**KIRKLEES METROPOLITAN COUNCIL
INVESTMENT & REGENERATION SERVICE**

**DELEGATED DECISION TO DETERMINE APPLICATIONS FOR
CONSENT, AGREEMENT OR APPROVAL REQUIRED BY CONDITION**

Reference No:	2023/44/93276/W
Site Address:	Hey Knowle Farm, Linfit Lane, Linthwaite, Huddersfield, HD7 5LF
Description:	Discharge conditions 3 (materials), 4 (improvements to access track and parking), 5 (waste collection) on previous permission 2021/94676 for erection of extensions and alterations to convert existing pig sty, domestic storage and WC building to single dwelling
Recommending Officer:	William Simcock

Officer Report 2023/93276

title Site plan and location plan
number 20141D-05-P04
scale 1:200, 1:100 and 1:1250
size A1

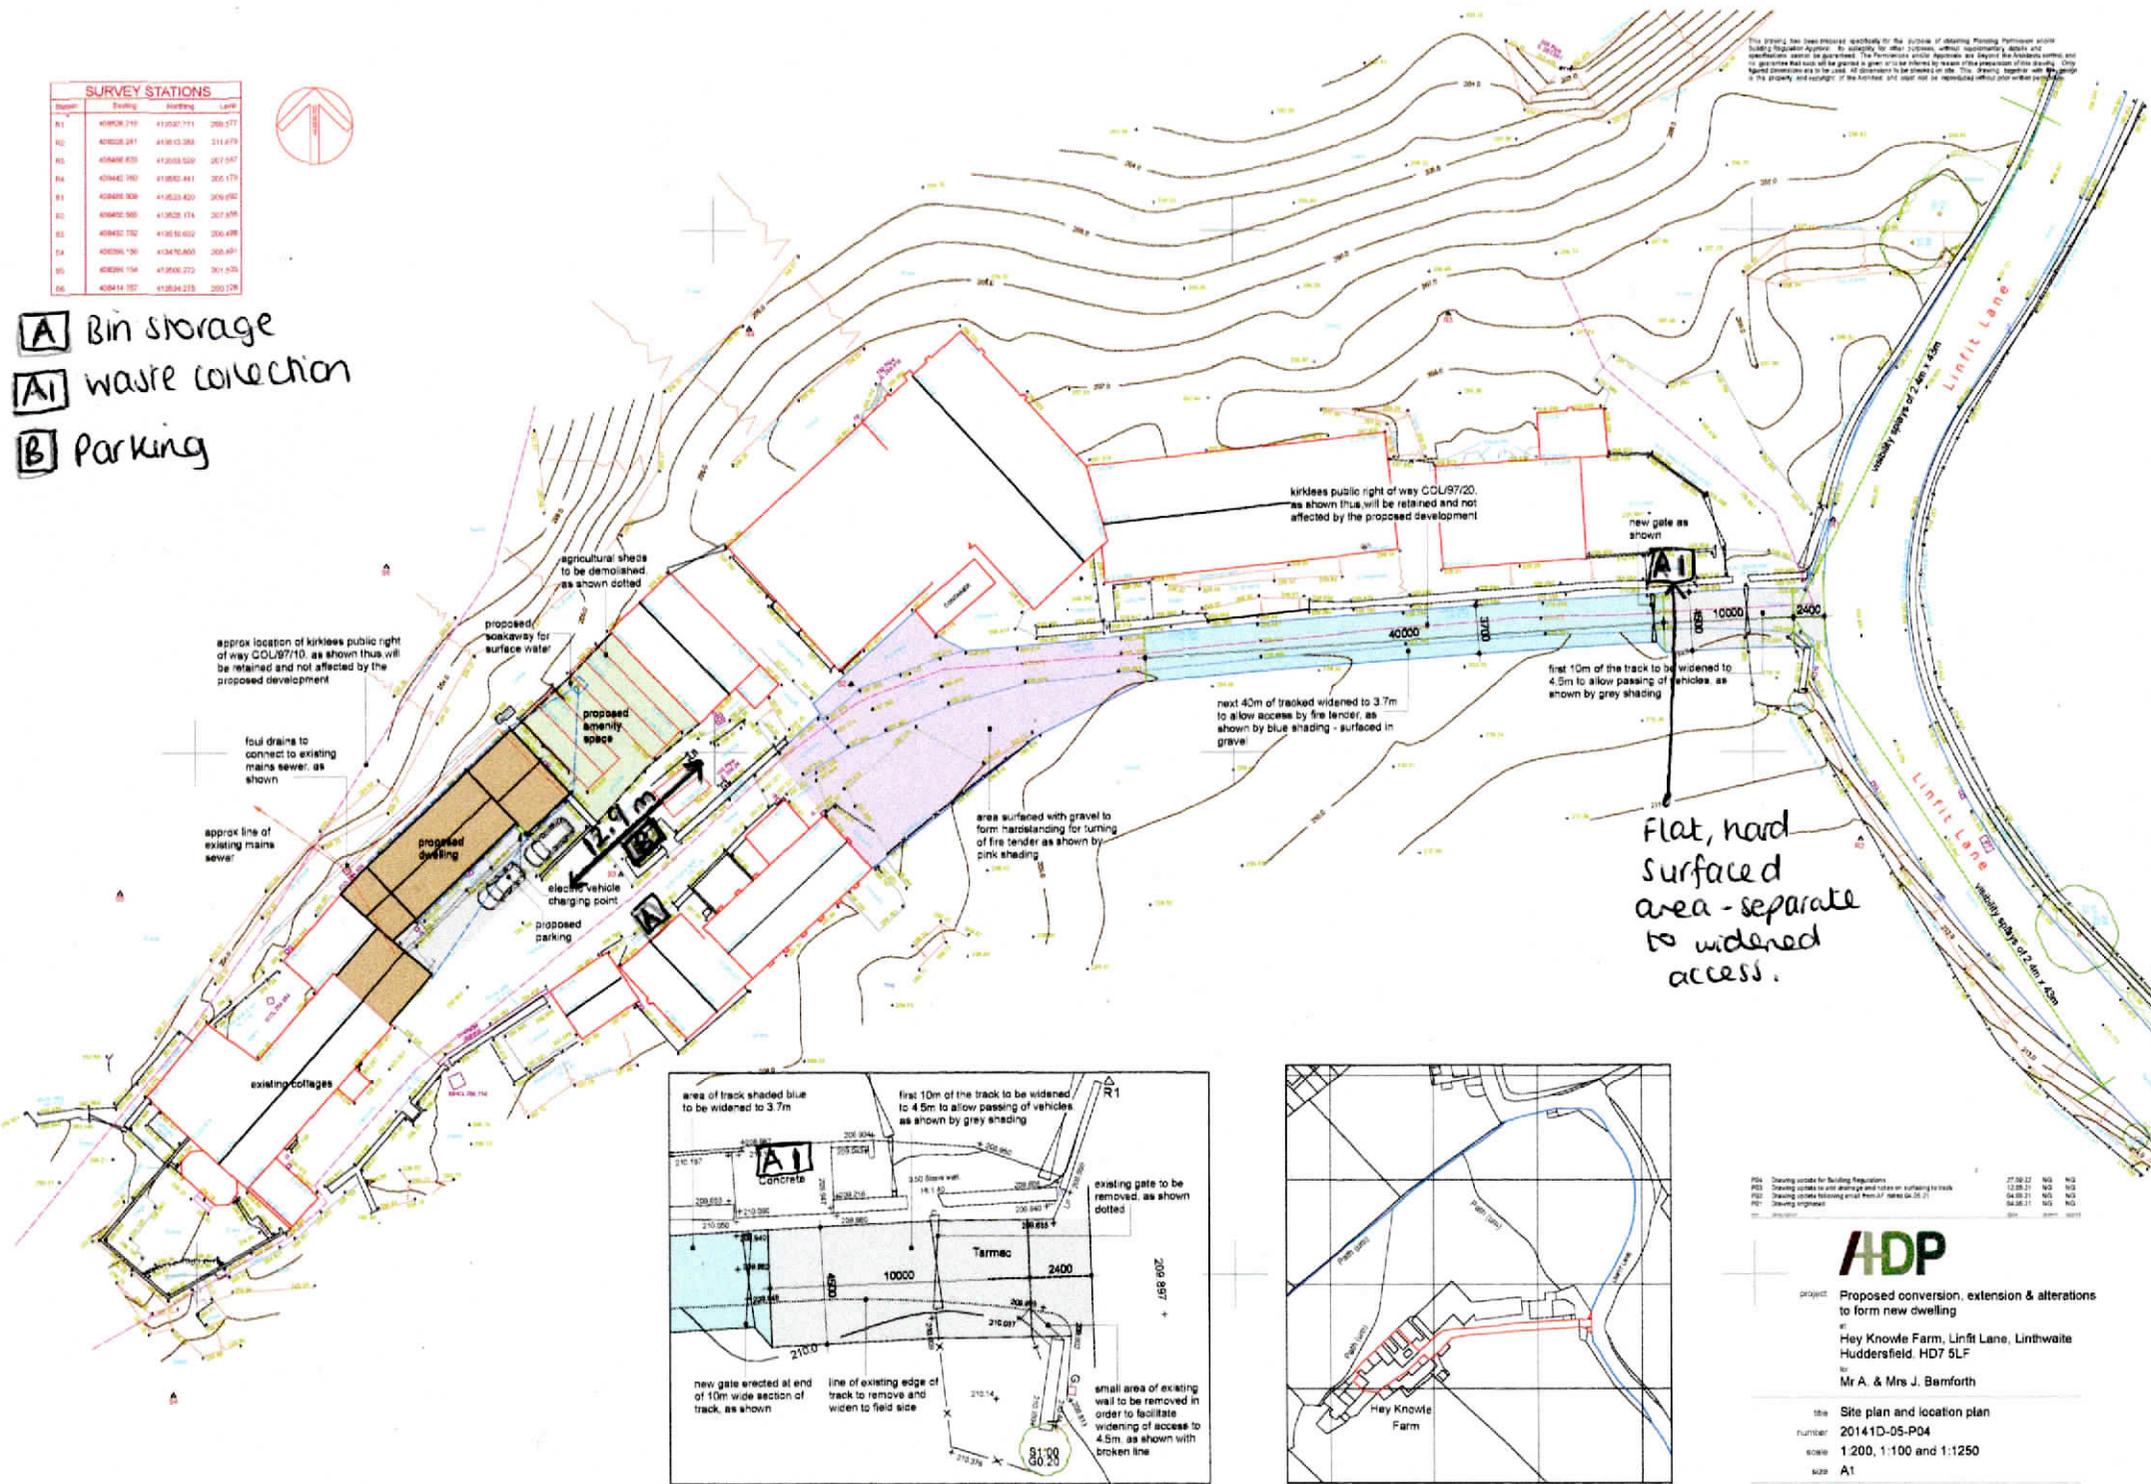
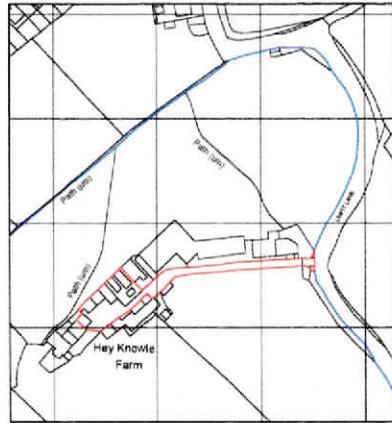
- Can the applicants be asked to confirm that the parking areas marked B have been cleared and appropriately surfaced for parking and that the parking spaces do not obstruct any access to other existing buildings.
- The bin presentation point marked A is shown adjacent to the access. Can the applicants confirm that this will be a flat hard surfaced area separate to the widened 4.5 metre access.
- The first 10m of the access from Linfit Lane should be shown to be hard surfaced, gravel or loose surfacing would not be acceptable at this location.

The location of the parking spaces is a departure from the plans as approved which showed them directly in front of the dwelling. On the plans being considered for this application, they are shifted eastwards. This is however considered immaterial in planning terms since they would not be taking up any space that was previously designated as being for the passage or turning of vehicles, or for private amenity space. The parking spaces as shown are considered acceptable in terms of size, layout, and ease of access.

The location and layout of the proposed bin storage facility and collection point as shown on the plan received 12th April 2024 are both deemed acceptable.

- The lane will be widened, excavated to a depth of 650mm, then filled with sandstone hardcore and finished with compacted tarmac plainings.
- Cars to be parked as shown at points B on adapted site plan showing in a black line that the removal of a temporary shed has made space for two car parking sites adjacent to the proposed amenity space.

The site plan shows three squares, sketched on in black pen, one labelled 'A' and two labelled 'B'. The supporting statement claims that waste bins, both green and grey, will be stored and collected from point 'A' on the adapted site plan 20141D-05-P04 as per the waste bins from Hey Knowle Farm and Hey Knowle Farm Cottage.

The case officer has discussed these arrangements with the Waste Operations Manager who has stated that bin collection for the existing dwelling is from the site entrance, and has advised that it is unlikely, in view of current standards and practice, that bin collection crews would be able to collect from point 'A' or 'B' as shown on the plans.

The squares indicated 'B' are however deemed acceptable as bin storage points for the two new dwellings.

It is therefore recommended that the plan and supporting statement be amended to show:

- The two areas marked 'B' designated as bin storage points for the new dwellings.
- The bin collection point on the access track just in from the junction with the adopted highway so that it does not obstruct the highway but is easily accessible.

The details of the parking spaces and access track shown on the amended site plan submitted 12-Apr-2024 are considered acceptable and are hereby approved.

The details proposed bin storage facility and collection point as shown on the plan received 12-Apr-2024 are both deemed acceptable.
